Application for Planning Permission for Works or Extension to a Dwelling

Development: Erection of two storey rear extension including the installation of 1 x rear juliette balcony and alterations to fenestration following the demolition of existing rear conservatory

Location: 25 Torton Hill Road Arundel BN18 9HF

PROPOSED BLOCK PLAN (1:500)

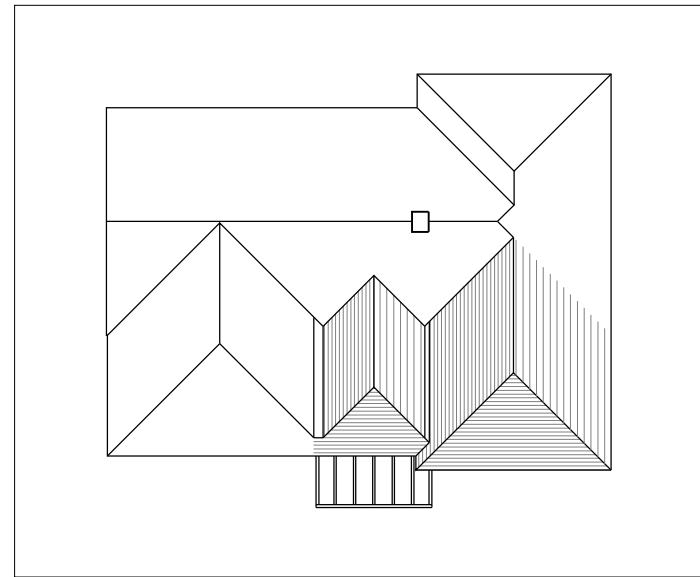
Block Plan

Please amend the block plan to include dimensions from the proposed extension(s) to all site boundaries at a scale of 1:500. Further details of what must be included on the plan can be found in the Validation Requirements List.
